Consultation Response from KC, Conservation and Design
2020/90949 169, Halifax Old Road, Birkby, Huddersfield, HD2 2RL
Erection of first floor rear extension and front and rear dormers (within a Conservation Area)
Date Responded: 11.5.20 Responding Officer: Sue Oakley Responding Ref:

PROPOSED SECOND FLOOR

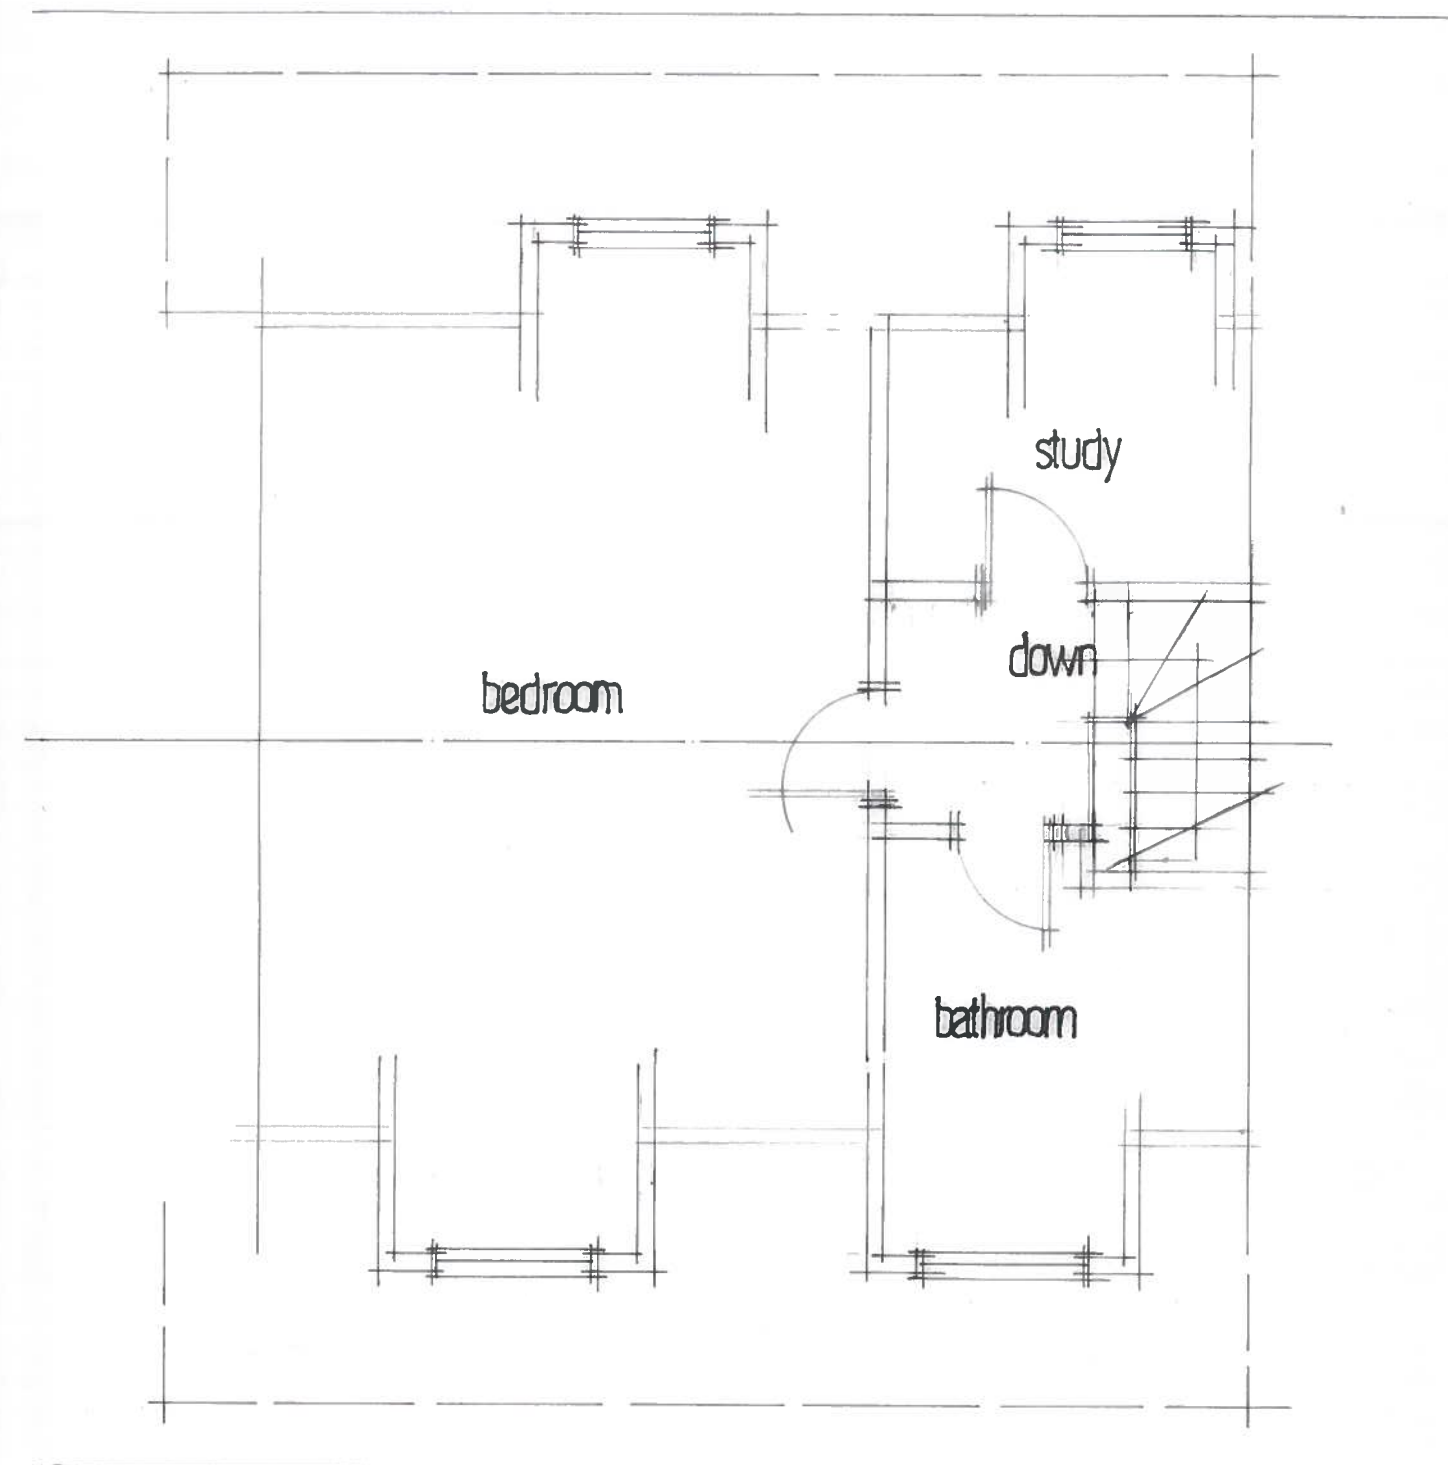
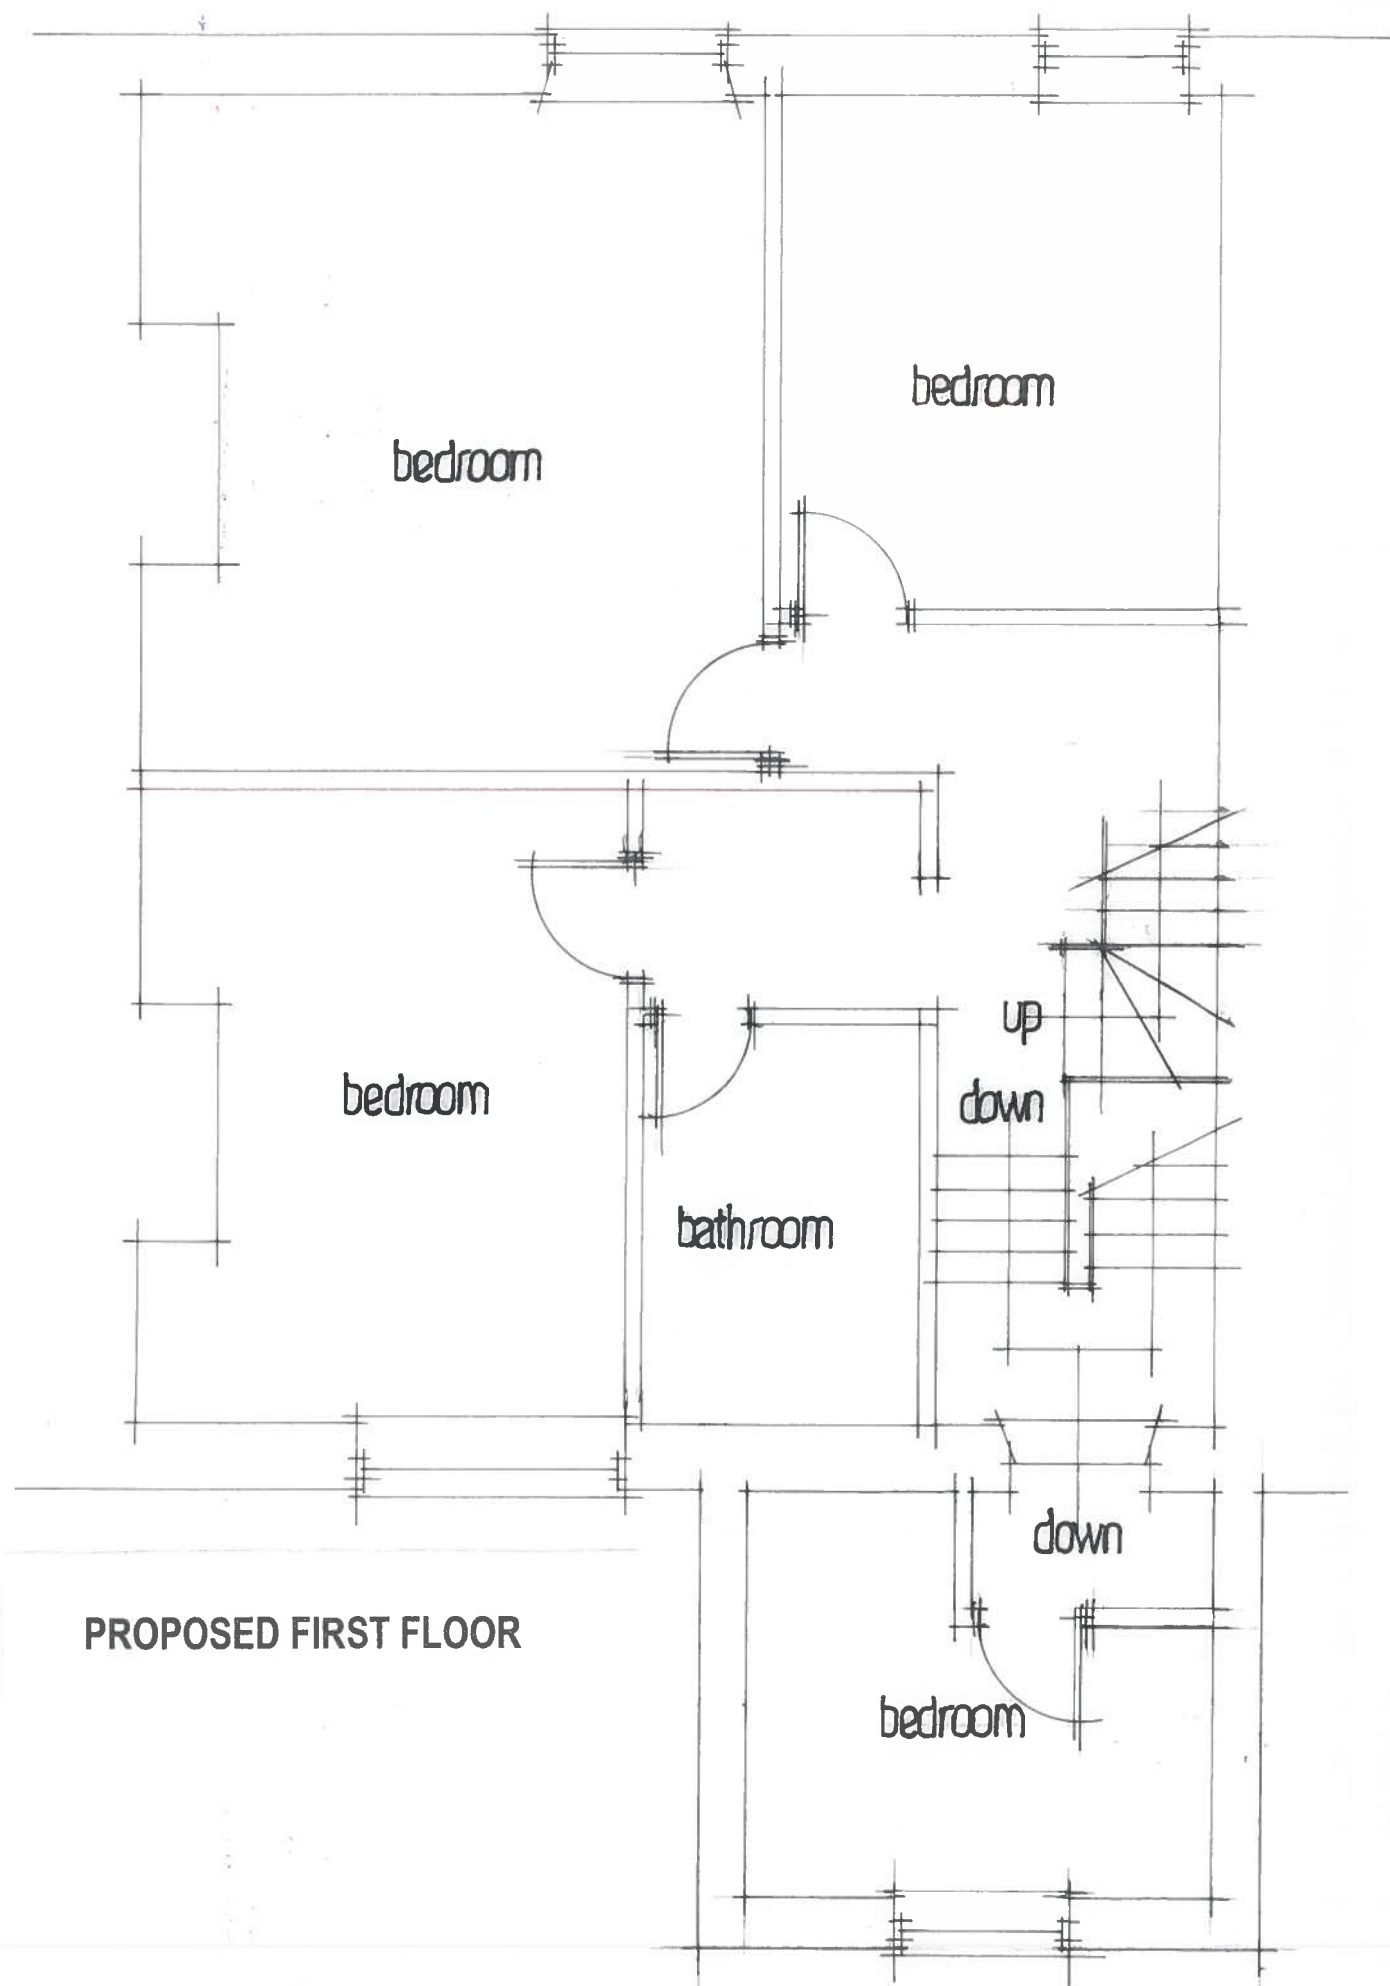
The Design, Access and Heritage Statement does not assess whether there is harm to the character and significance of the conservation area or provide justification for the proposal. There are two existing bedrooms on the second floor of the house, and I would question the need for a study and additional bathroom on this floor. No public benefits have been given to outweigh the harm, and I do not consider the proposal to be necessary to secure the optimum viable use for the building.

PROPOSED EXTENSIONS
169, HALIFAX OLD RD, BIRKBY, HUDDERSFIELD
DRG.NO.2009.7 SCALE 1: 50

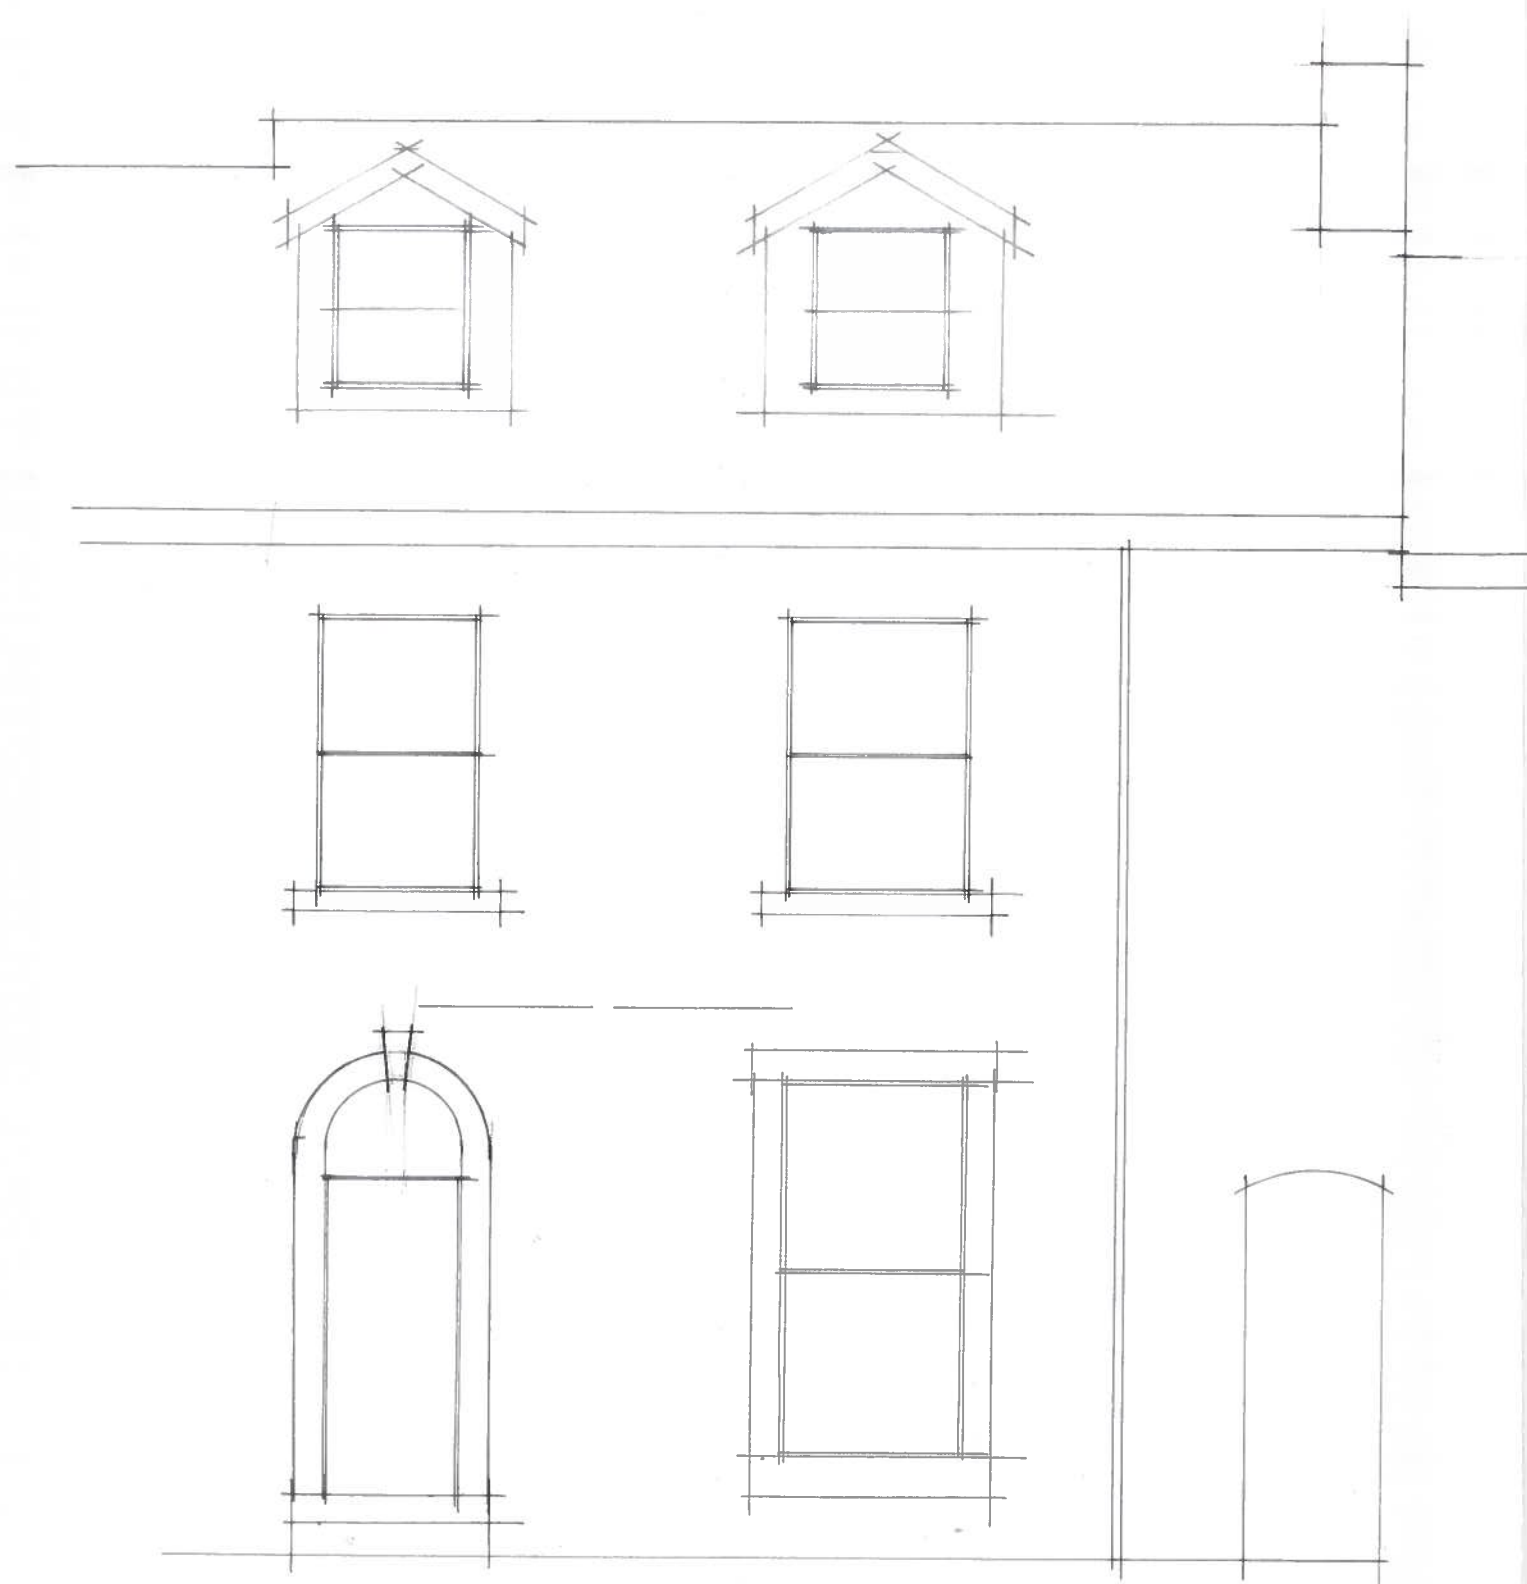
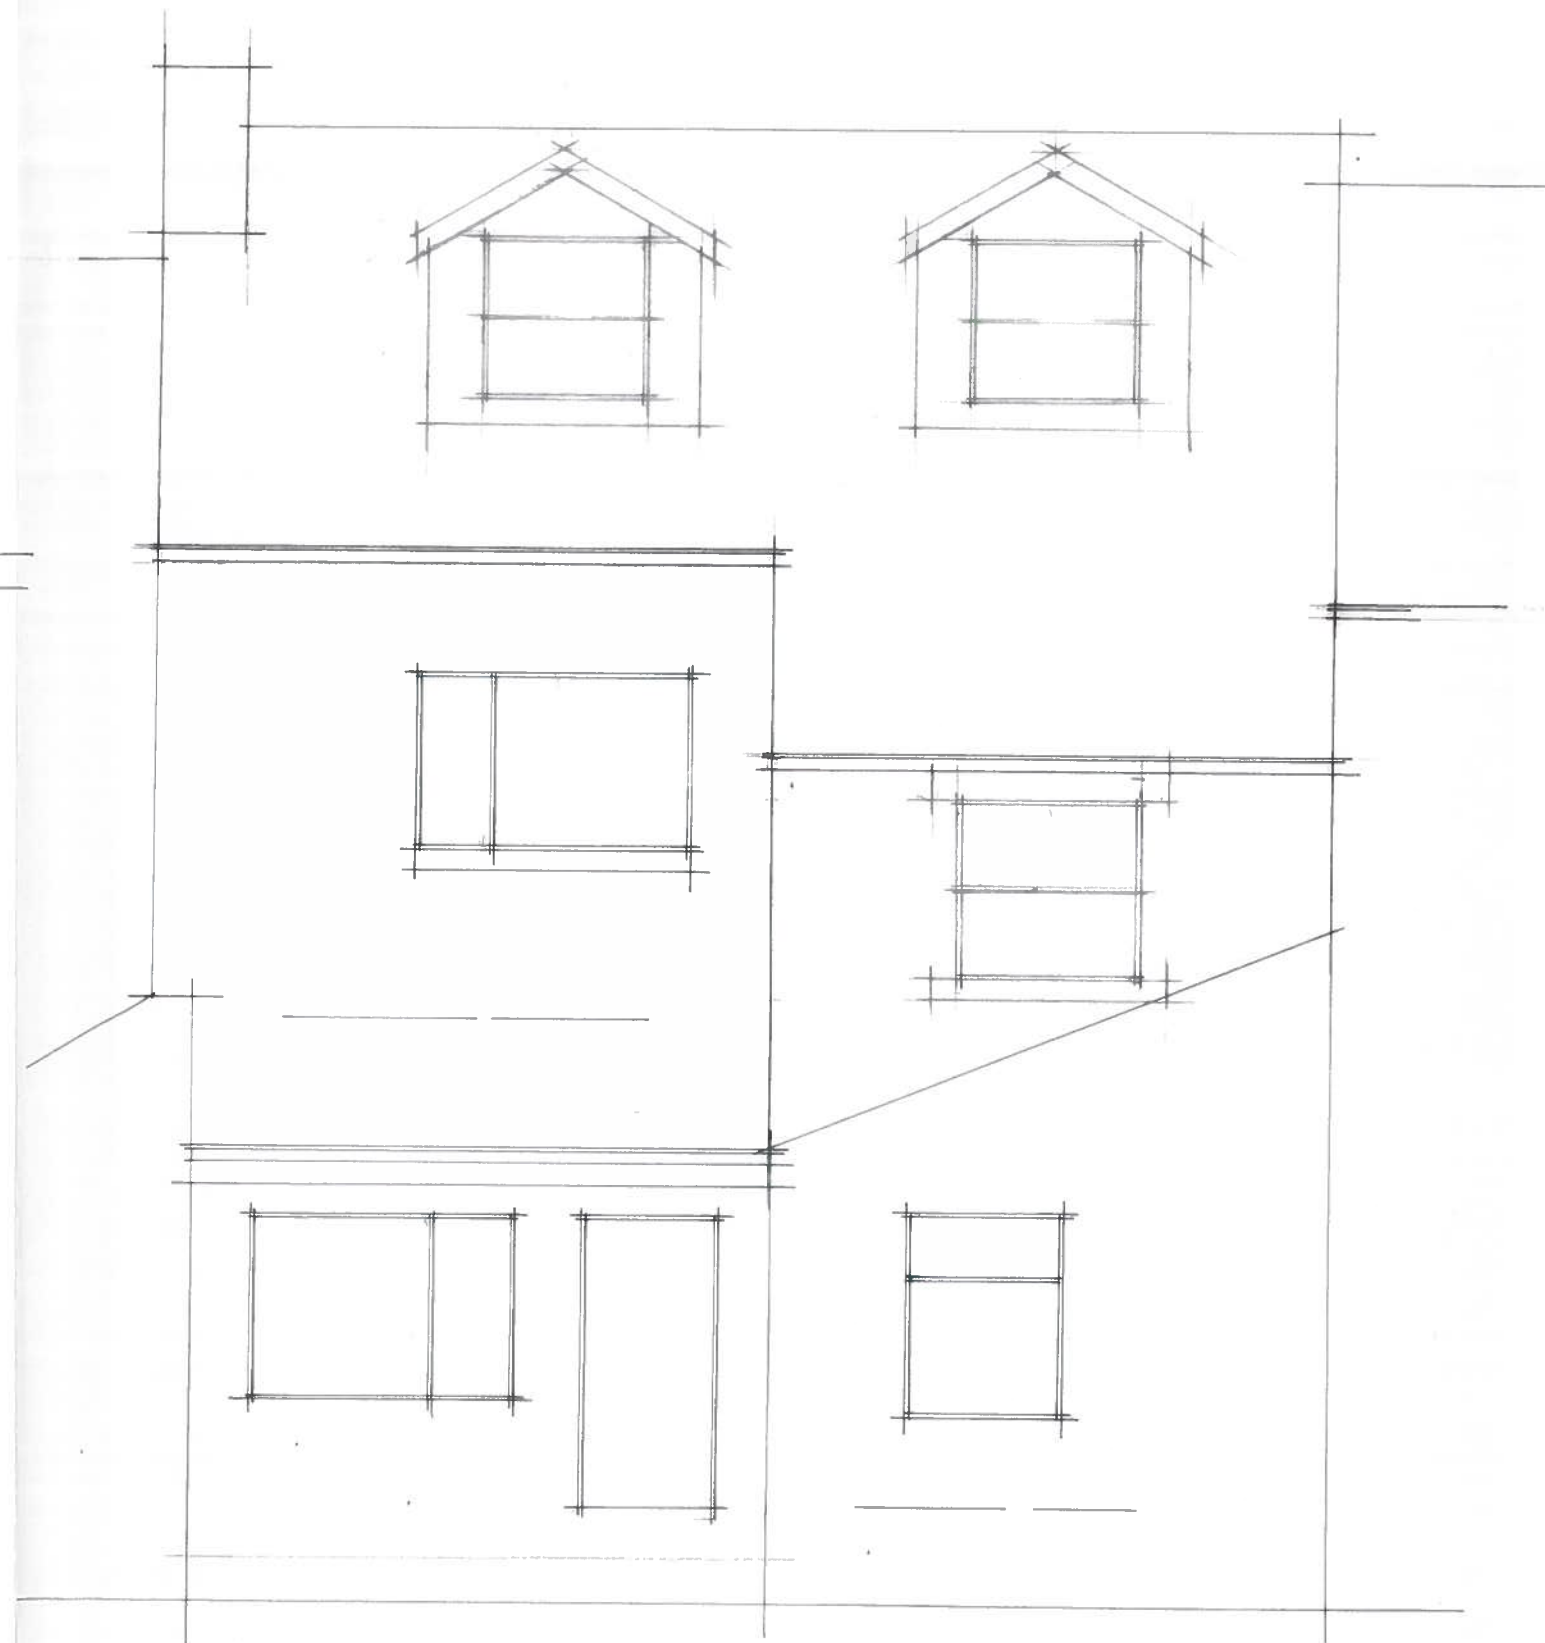
To the front and rear of the building two small dormers are proposed on each roof pitch, clad in slate with slate roofs and uPVC windows. Although they are of a traditional design, I consider that inserting dormers will lead to less than substantial harm to the significance of the conservation area (NPPF paragraph 196), by altering the original form of the roof and detracting from the characteristic repetition of the terraces. The harm will be particularly pronounced on the front roof pitch facing Halifax Old Road. Although the harm to the rear will be less, there is no justification for this, and I would prefer other options to be considered. Rooflight windows on the rear would be acceptable.

In this case, the repetition of the terraces and clean roof lines are an important part of the character of this conservation area and contribute to its significance.

I have no concerns about the proposed rear extension although I do not support dormer windows and would welcome amendments.

The proposed rear extension is in render with a slate catslide roof and uPVC windows. I have no concerns about this proposal as the rear elevation makes a limited contribution to the character of the conservation area, although I would prefer the existing kitchen extension roof to be altered to a lean-to to reduce the different roof pitches on the rear.
